## Land at North West Bicester

### Technical Note 2: Response to LLFA Drainage Comments

18<sup>th</sup> March 2022

Appendix A – Illustrative Surface Water Drainage Plan (10663-DR-01 D)

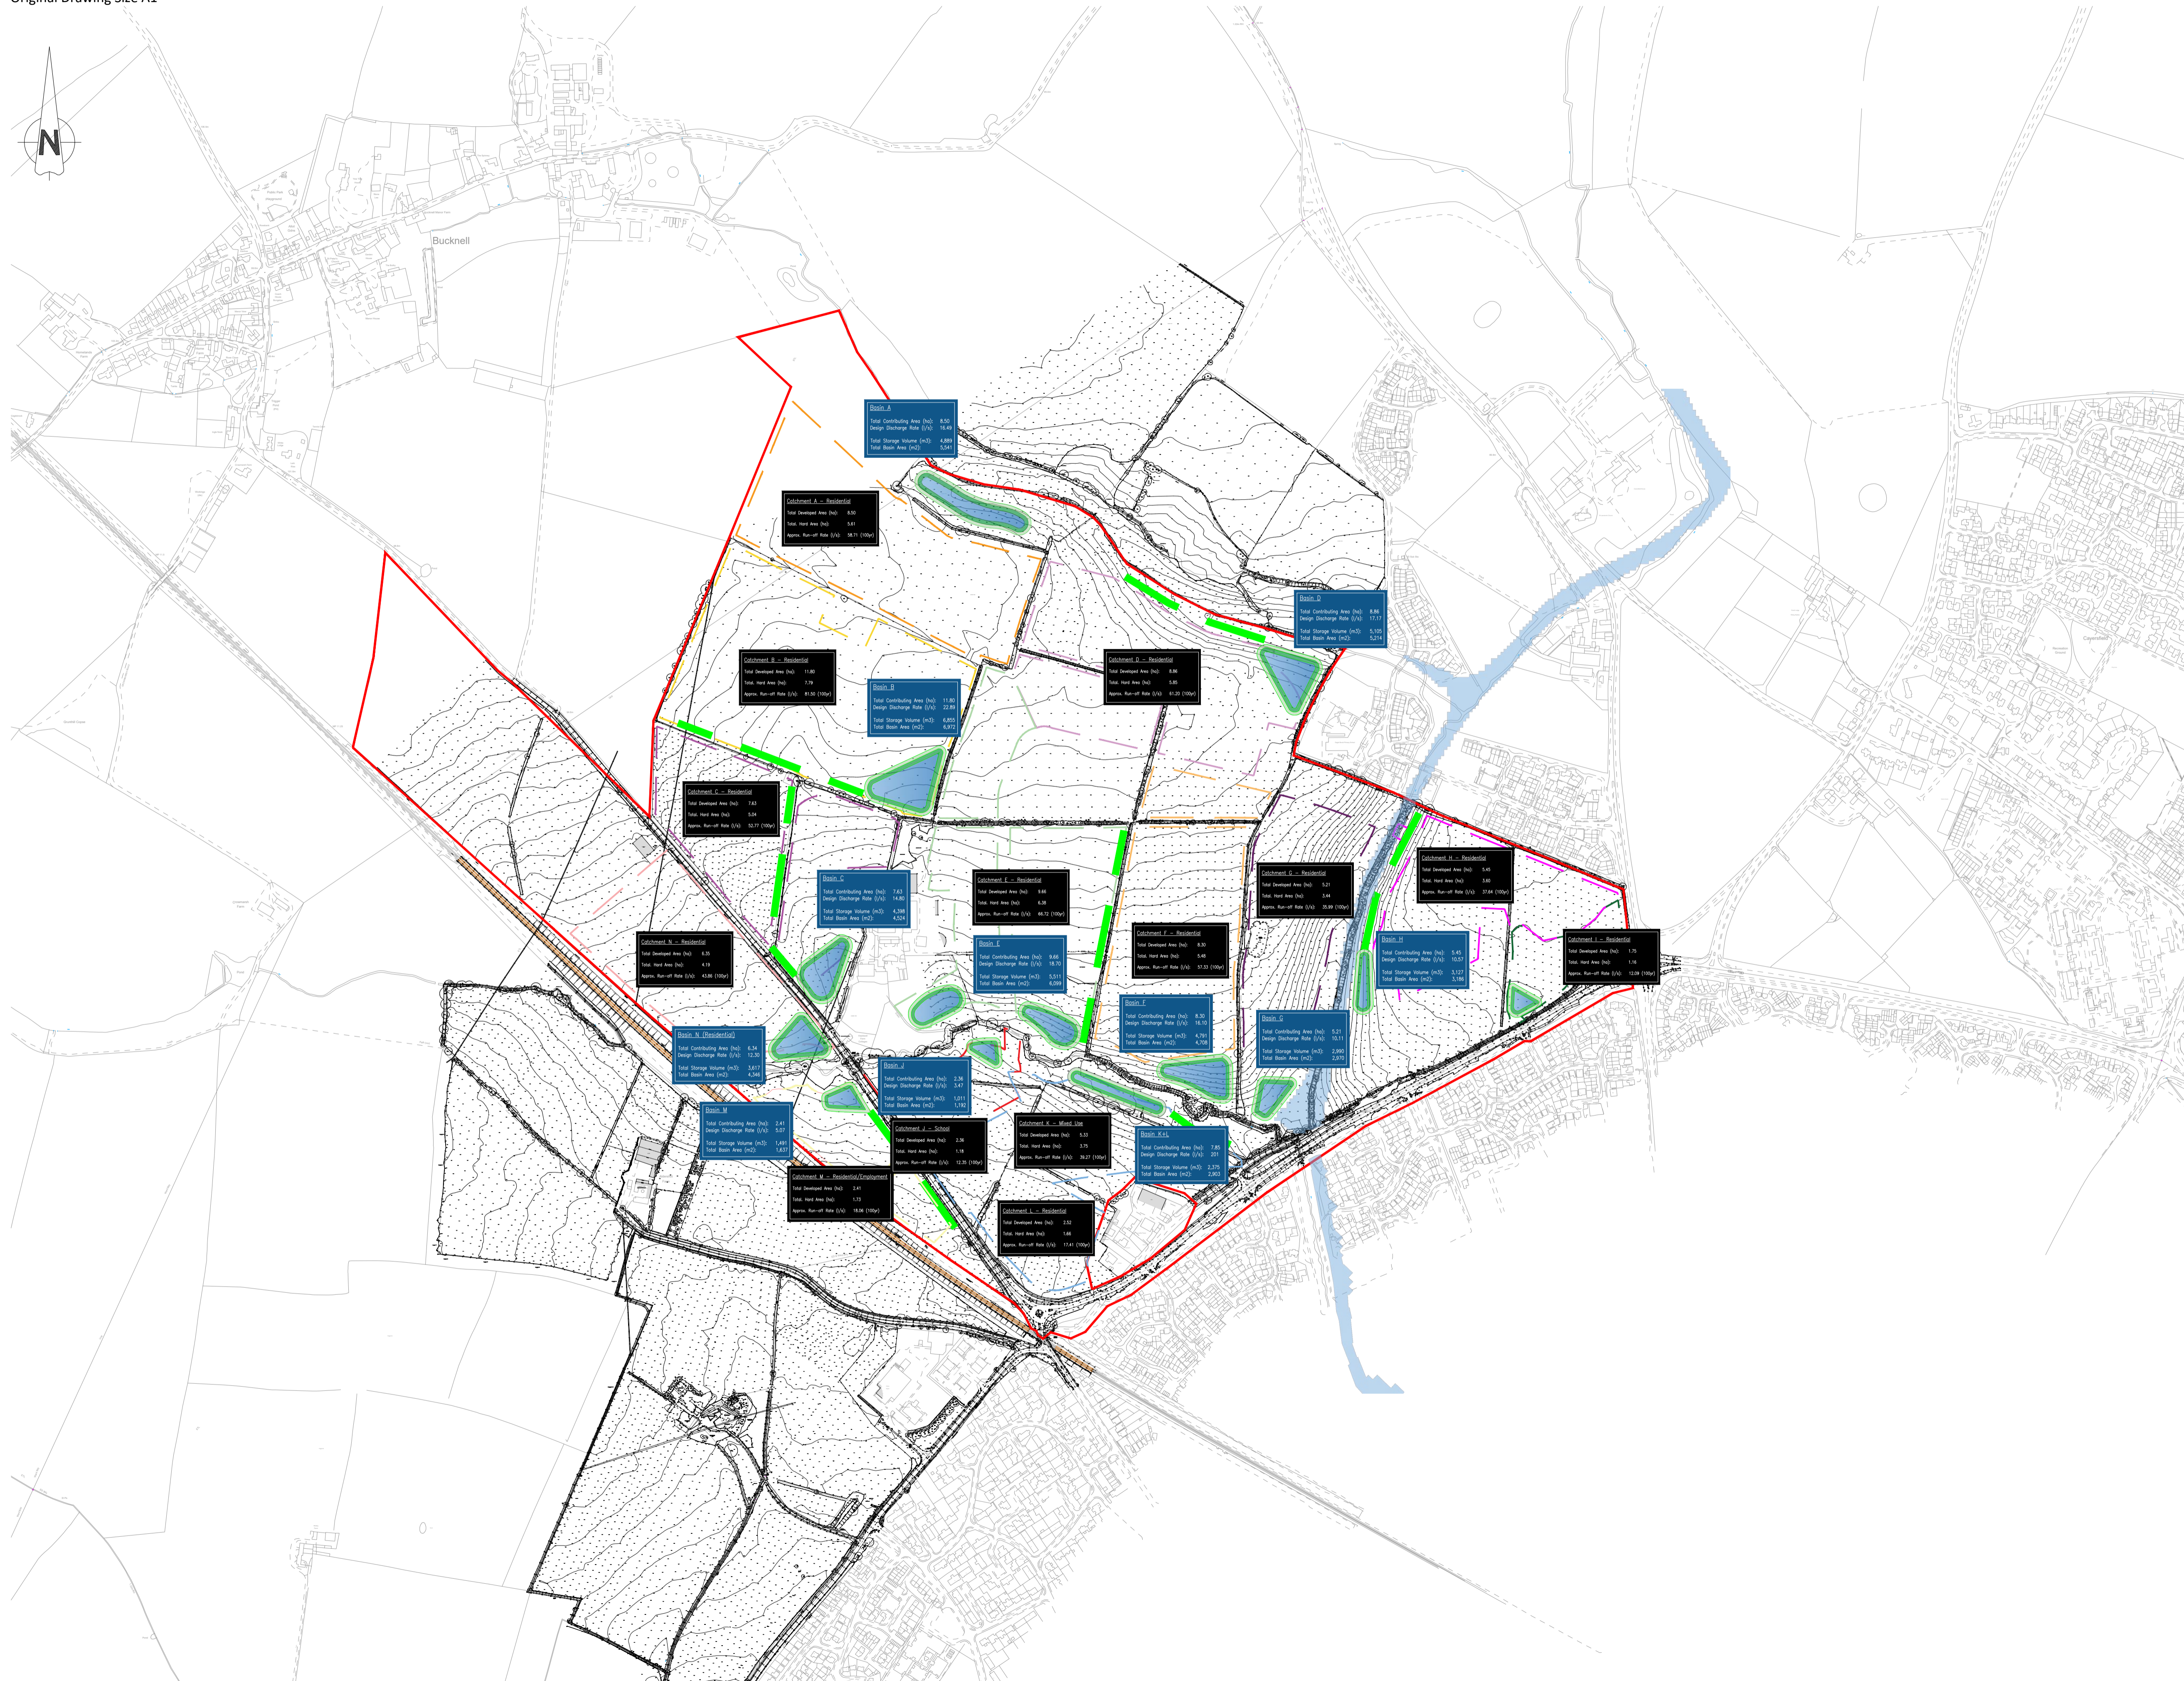
- 2.3 *The FRA explains the surface water drainage strategy however a surface water drainage drawing is required to demonstrate the surface water strategy. Proposed SuDS features and drainage infrastructure needs to be shown indicatively. Outfall locations to be shown, storage details of proposed SuDS features and infiltration rates if applicable.*

- 2.7 The yellow circle on the plan indicative a suggested outfall location for each of the basins.
- 2.8 *The catchment areas have been broken down in the FRA, however a Catchment plan is required to highlight the extent of the areas. Stating the total impermeable area and the impermeable area including urban creep.*

**2.11** *Surface water exceedance flow plans required to demonstrate how the site is draining to ensure all surface water is being picked up by the proposed drainage infrastructure.*

- 2.4 A drainage strategy plan (10663-DR-01 D) has been provided as Appendix A of the Flood Risk Assessment (FRA). Drainage Strategy 10663-DR-01 E, have been appended to this note. This strategy plan includes clearer catchments areas and exceedance routes. The split between impermeable catchment area and impermeable area with urban creep has also been provided on the new plan.

- 2.5 The proposed strategy for the site includes individual catchment swales and detention basins, all of which discharge into one of the onsite watercourses.

- 2.6 On the drainage plan, the fourteen catchments have been coloured coded and each basin has its own blue information box. Within this box provides the area of the catchment, designed discharge rate, area of basin, m<sup>2</sup>, and the volume required, m<sup>3</sup>.

- 2.9 Illustrated on drainage strategy plan (10663-DR-01 E), are the fourteen colour coded catchment areas across

**2.10** The black information boxes on the DR plan states:

- the catchment area,
- impermeable area,
- impermeable area with urban creep,
- the existing 100-year runoff rate.

**2.12** Plan 10663-DR-01 E, illustrates a series of swales adjacent to the edge of the catchment parcels which will convey surface water from that parcel into the associated catchment detention basin.

**2.13** Exceedance flow routes are also illustrated for the basins that are not directly adjacent to one of the onsite watercourses.
